Appeal Decision

Appeal Ref: APP/A2525/W/17/3184614

215 Bridge Road, Sutton Road, Spalding PE12 9SL

- The appeal is made under section 78 of the Town and Country Planning Act 1990 against a refusal to grant planning permission.
 - The appeal is made by Mr Andrew Lilley against the decision of South Holland District Council.
 - The application Ref H18-0358-17, dated 12 April 2017, was refused by notice dated 4 July 2017.
 - The development proposed is pair of semi-detached houses and one detached house.
-

Drawing	Vehicle Turning Details
---------	-------------------------

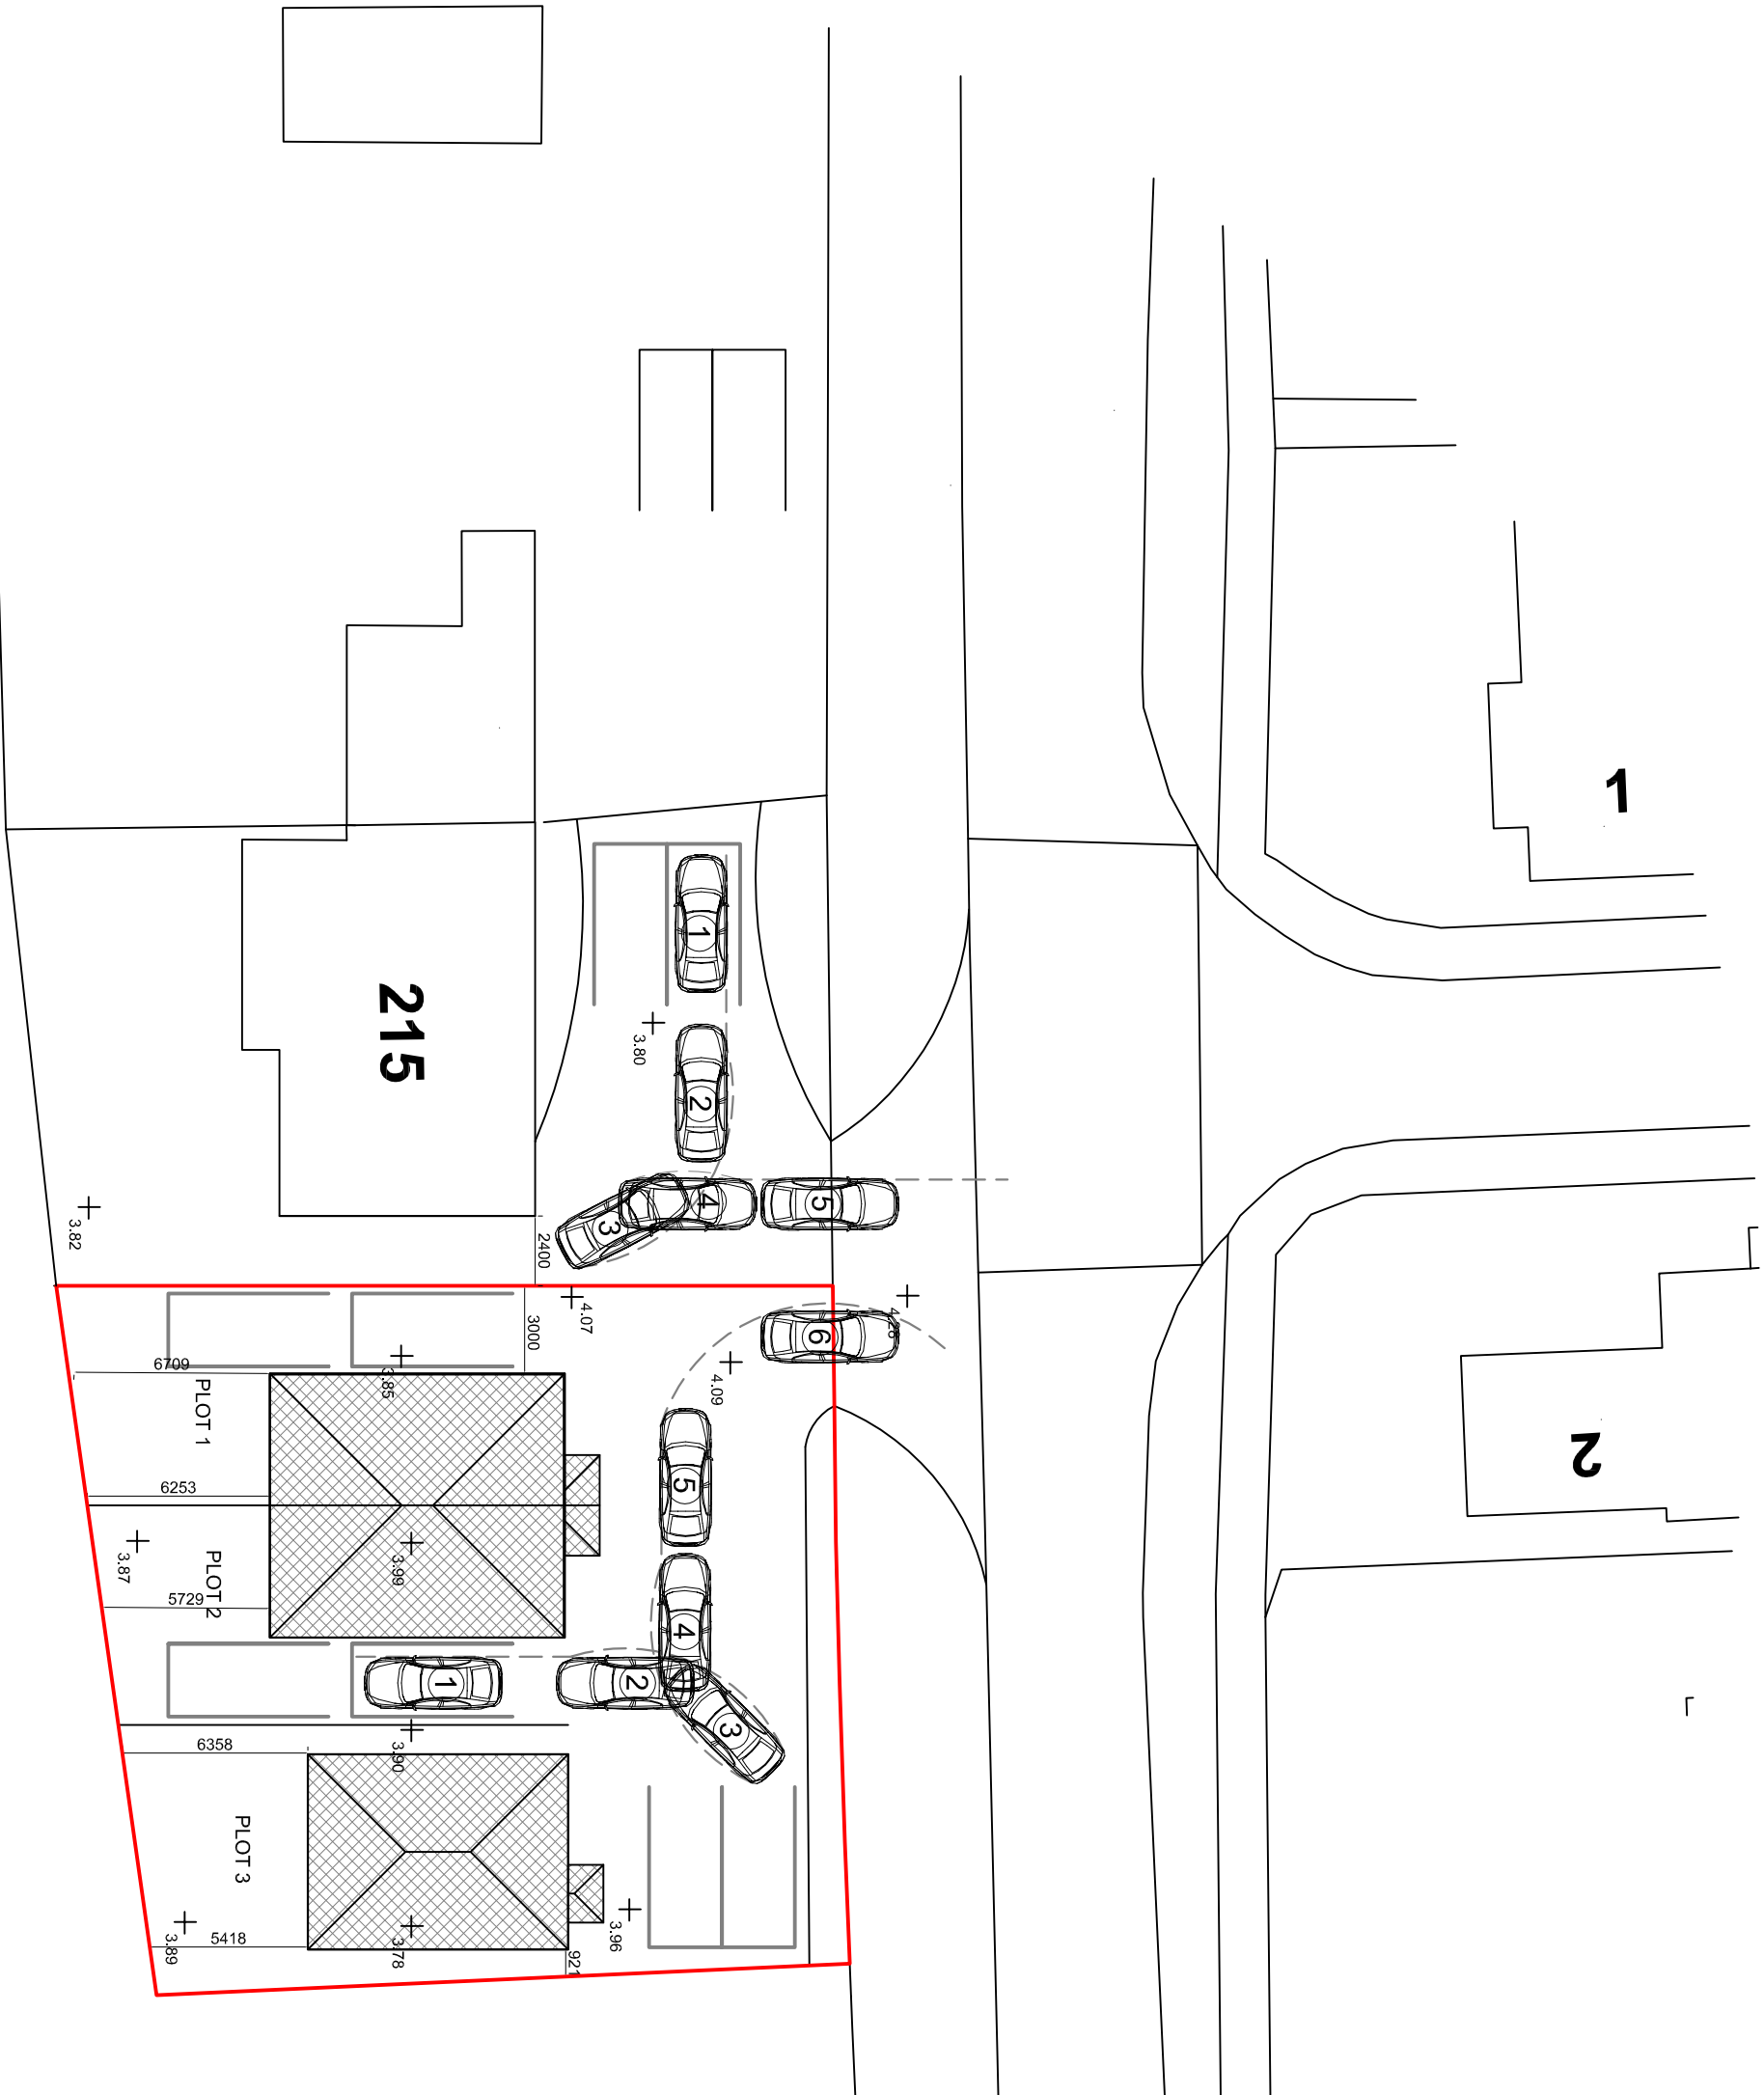
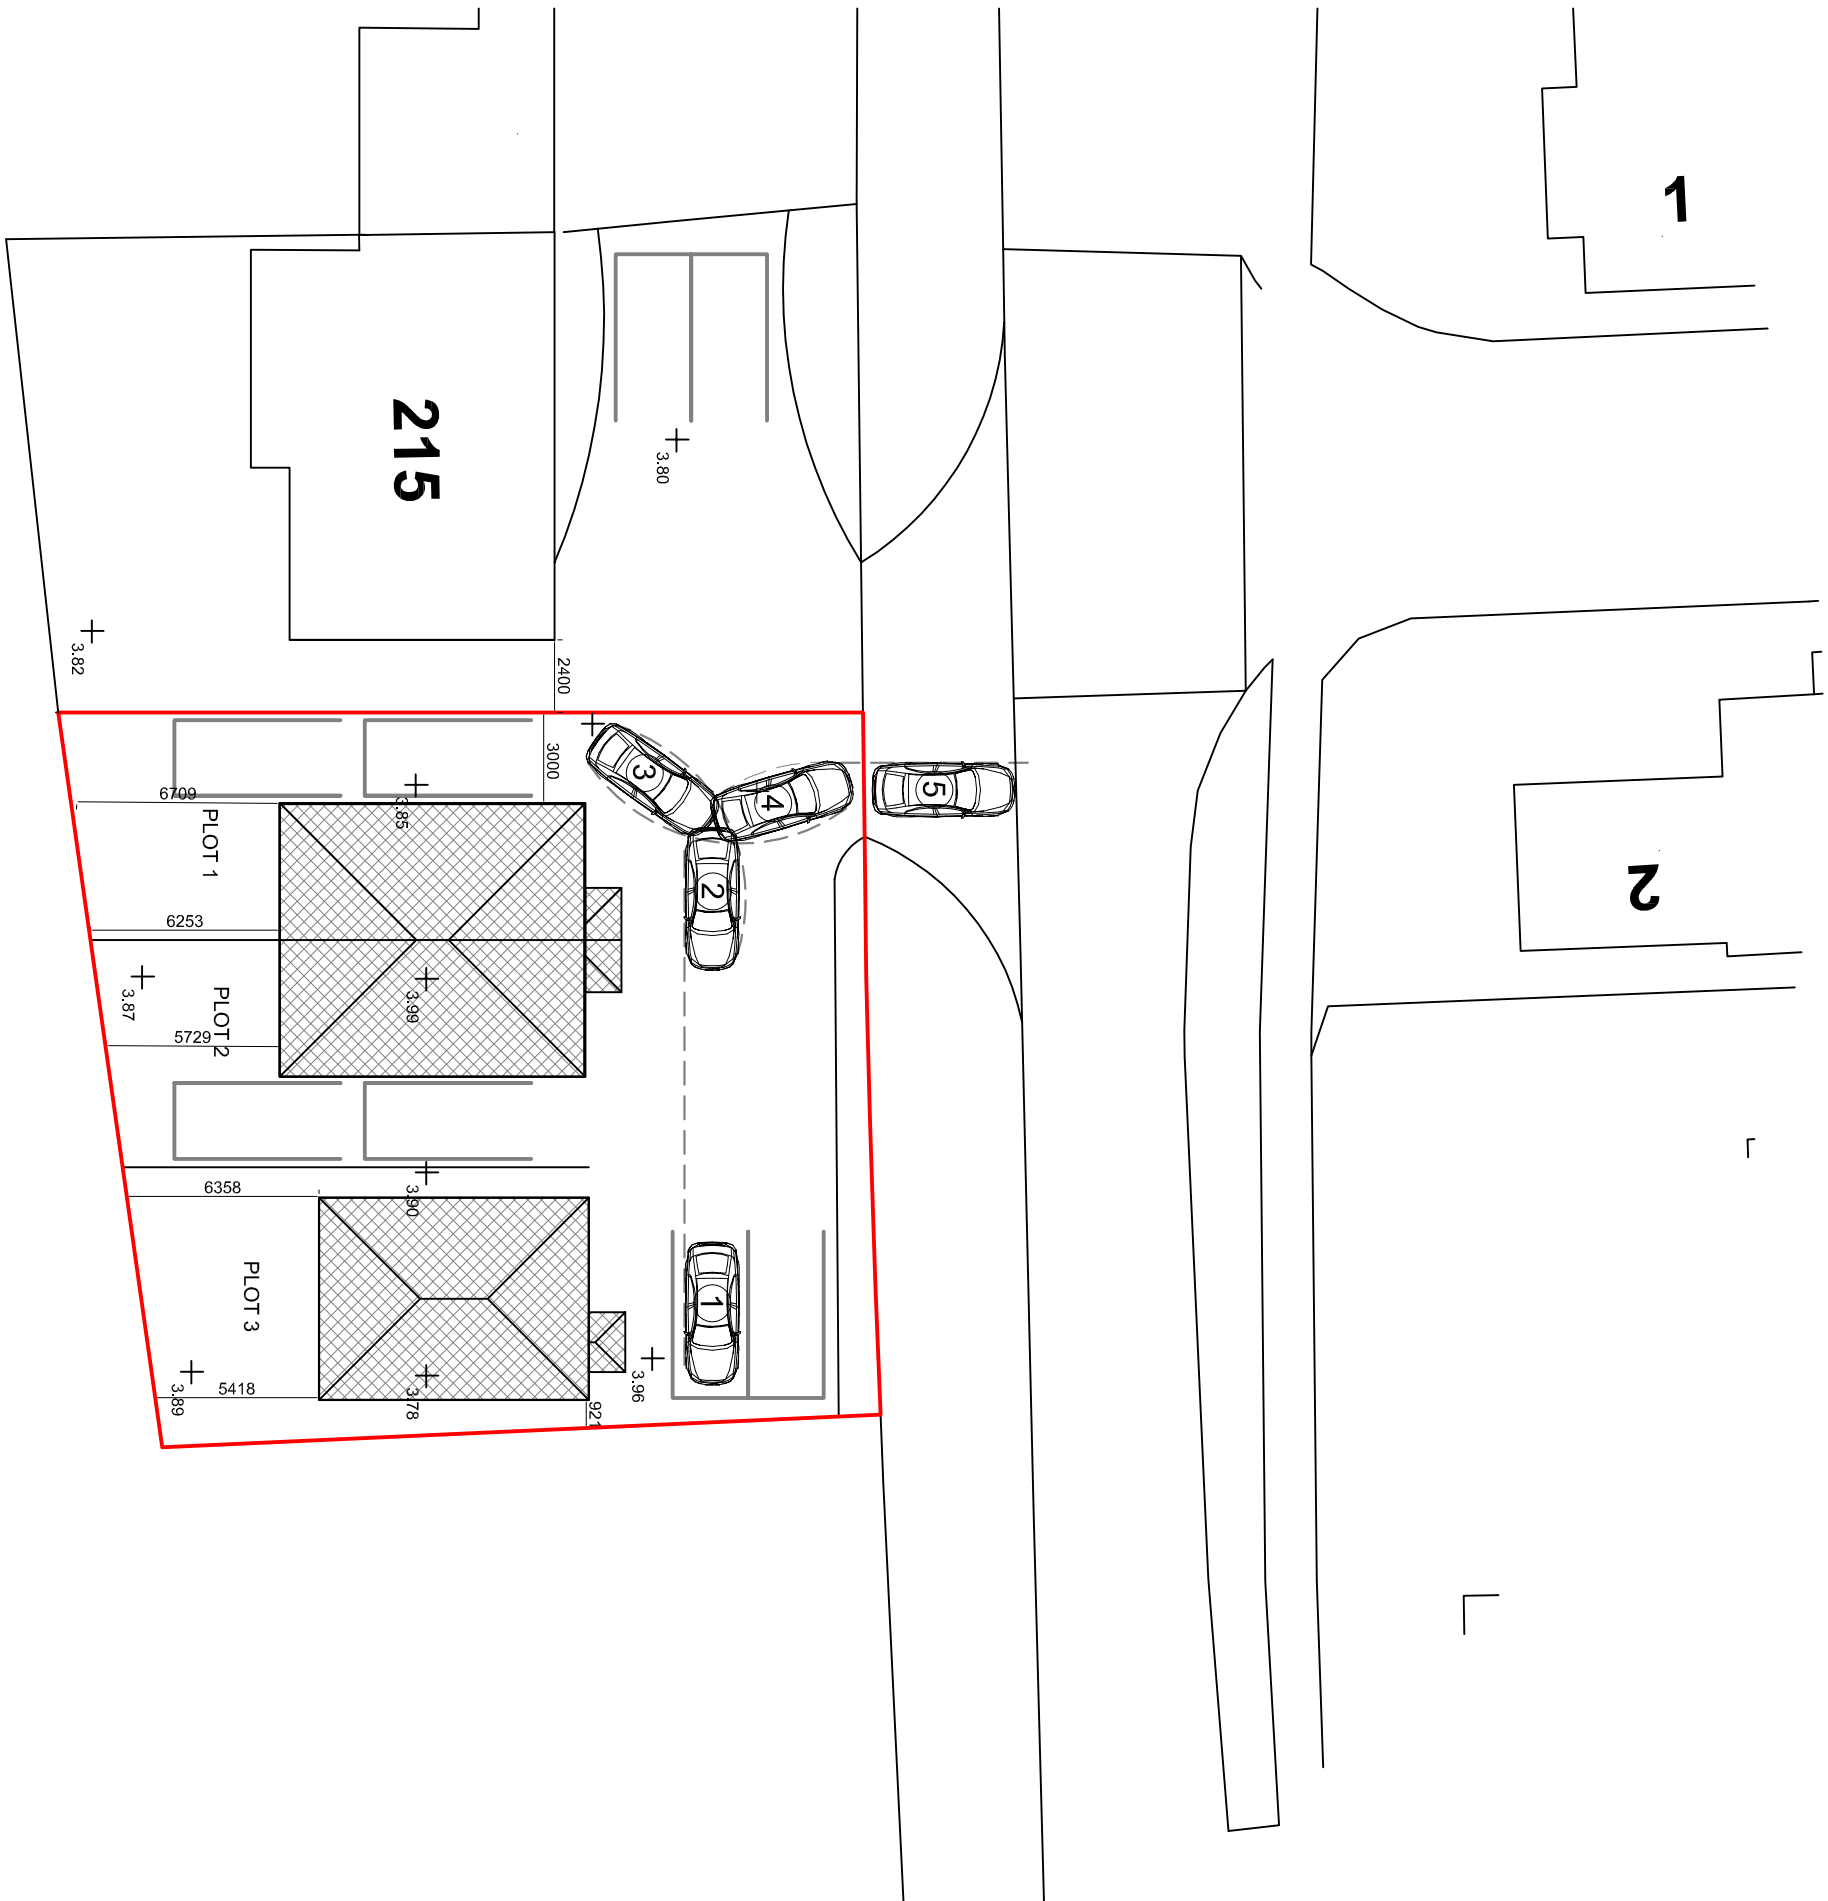
5. There does not appear to be any buffer or separation between the turning space in front of the semi-detached dwellings for vehicles manoeuvring in and out of the parking bays. This is confirmed by the appellant's diagram of the parking manoeuvres required for vehicles to leave the site in forward gear, which shows vehicles from Plot 3 turning very close to the front elevation of Plot 1 in order to exit the site.

6. Having reviewed the space available I conclude that multiple turns would be needed directly in front of Plots 1 and 2 for all vehicles to turn within the site. Furthermore, if both parking bays for Plots 1 and 2 were in use, access and egress from the inner bay would also require multiple turns and the temporary blocking of other parking bays on the site. I acknowledge that vehicles could leave the site in forward gear but this does not alter my reasoning in respect of excessive manoeuvring and proximity to the dwellings.
